Your Ref: OWPC14159
Our Ref: AL/47/17/HH 26-04-2017
Please ask for:
Mark Jones

Temporary erection of 2.4m high fence
Mapsons Lidsey Road Bognor Regis

Thank you for your internet representation made on 5th June 2017 which has been recorded as '**an objection**' with the comments as follows:

PROPOSED
TEMP. FENCE.
1:20

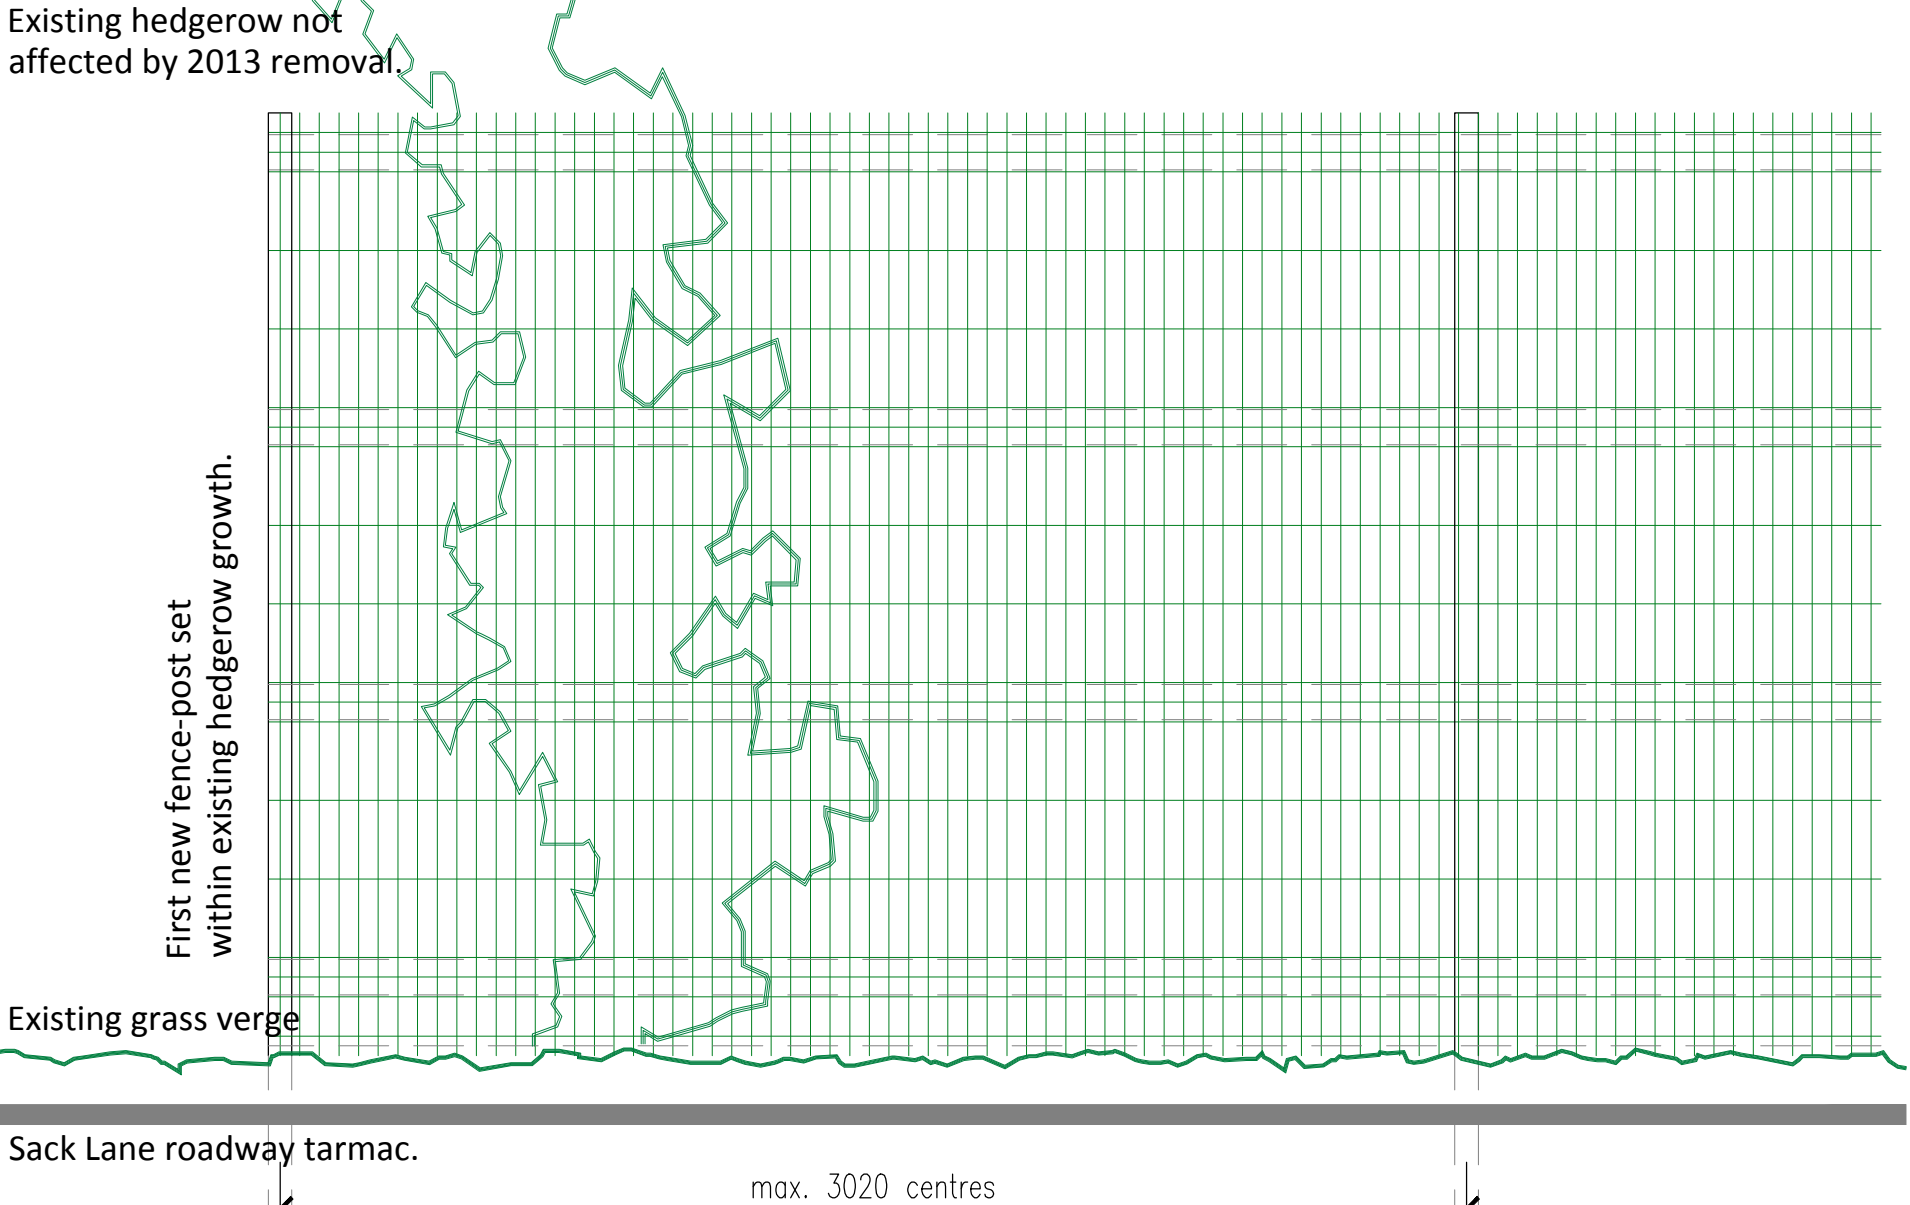
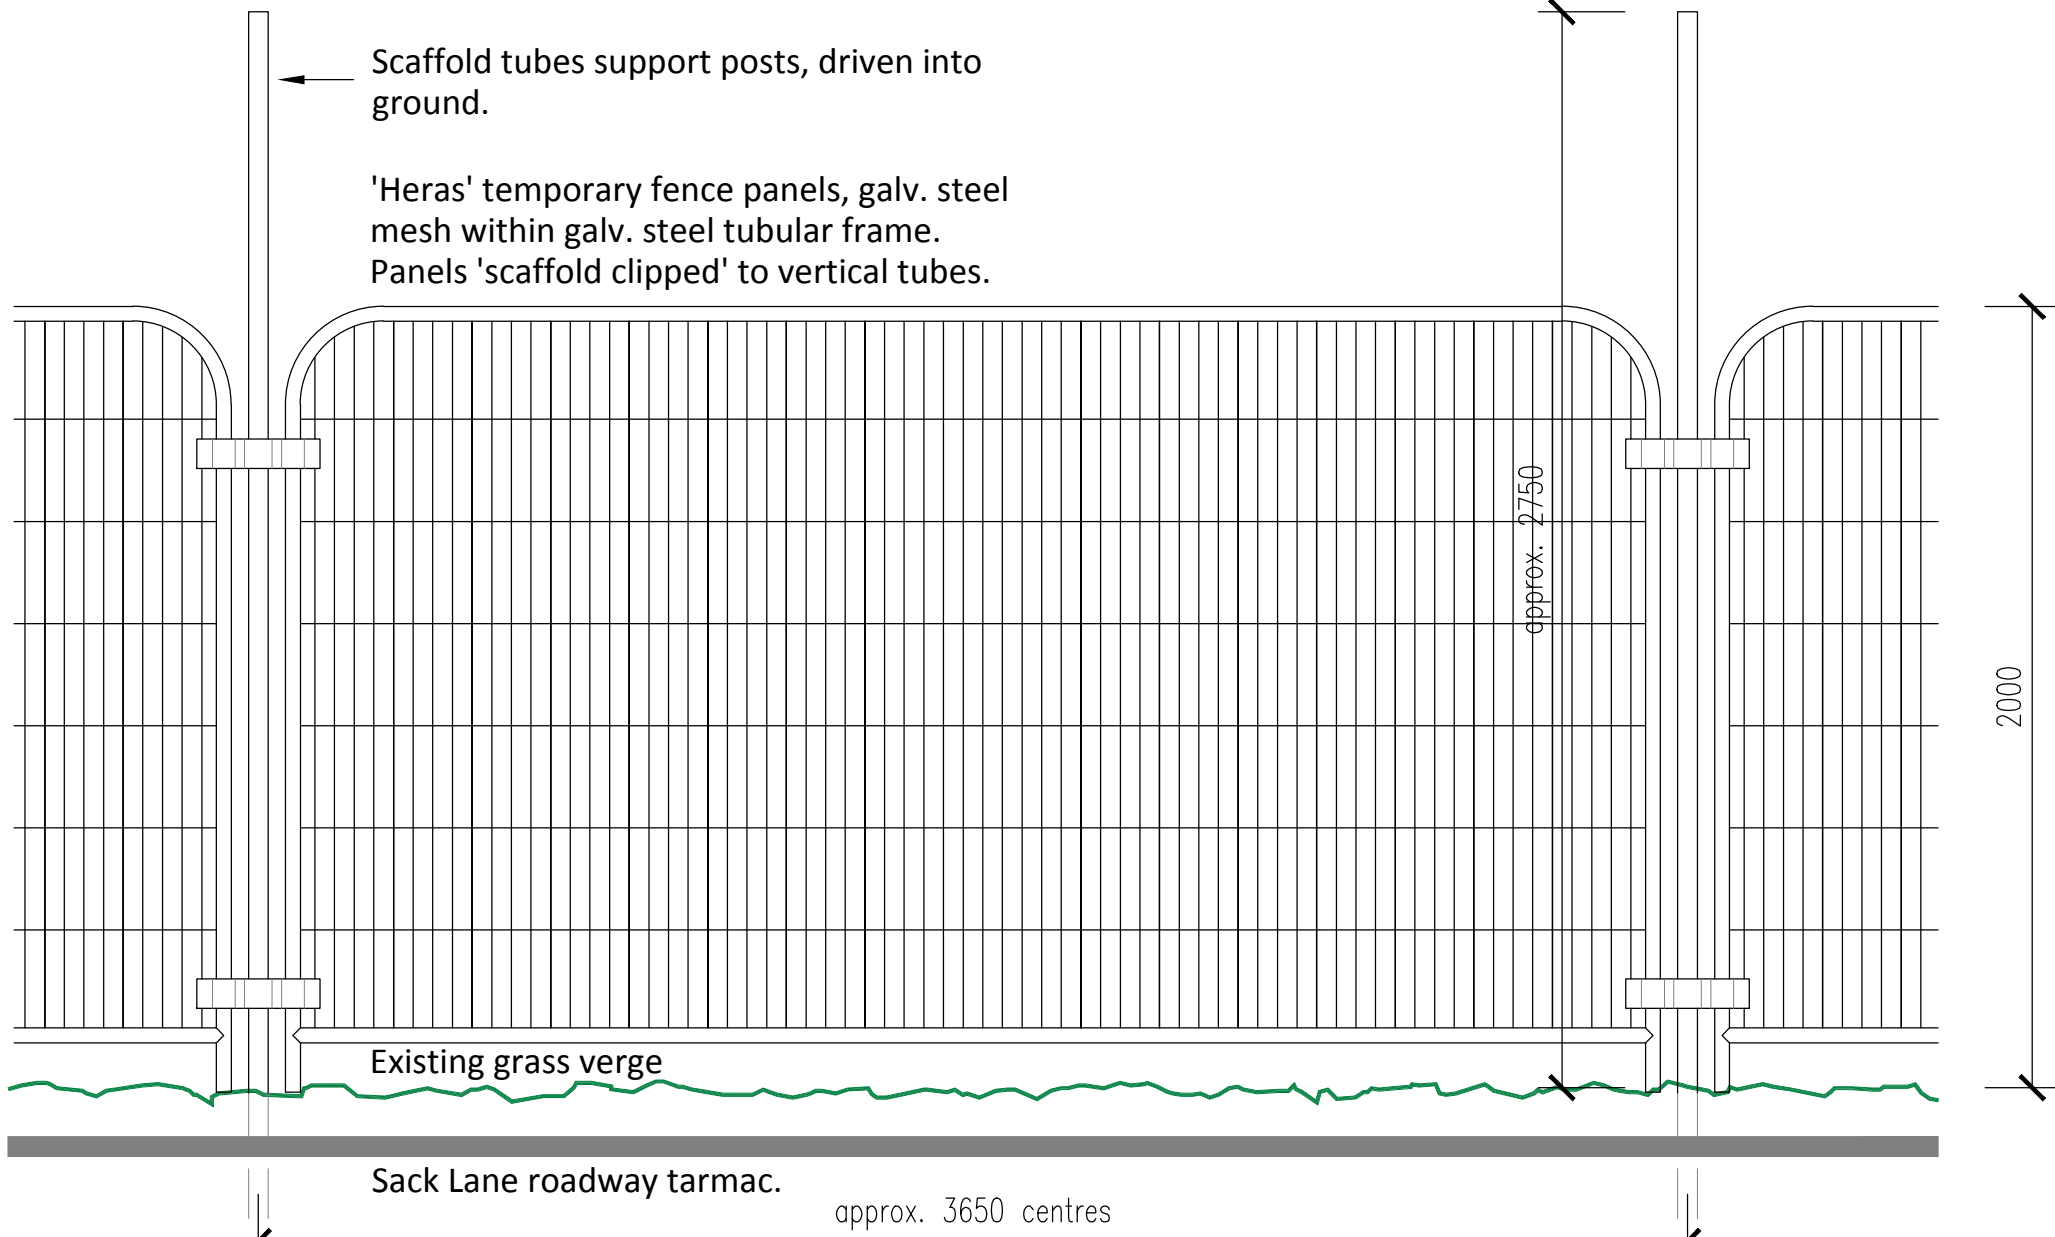
We are writing to object to this application on the following grounds:- we feel the proposed fence is too high at 2.4m and out of character with the surrounding countryside. In our view, it is also wrong that the proposed fence is to be placed on the south side of any planting as this would surely restrict the necessary light required to establish any hedge and allow it to grow to its best potential. A north side position would also probably be preferable from a security aspect as that seems to be an issue for the applicants. We also feel the fence would be very difficult, if not impossible, to remove once any hedging has grown through it and would therefore not be temporary as stated. If the intention was to be temporary, the land owner would not be asking for a "No time limit" (supporting document 4.7). We are not aware that the existing growth has been trimmed over the last 3 years and currently the chevron warning for the bend in the A29 is almost entirely obscured, as is the road sign for Sack Lane. Visibility is restricted when turning into Sack Lane, coming from Westergate. This is already a tricky entrance to turn into and the extra width at the entrance is really needed in case the farm tractors/vehicles or lorries are approaching the junction.
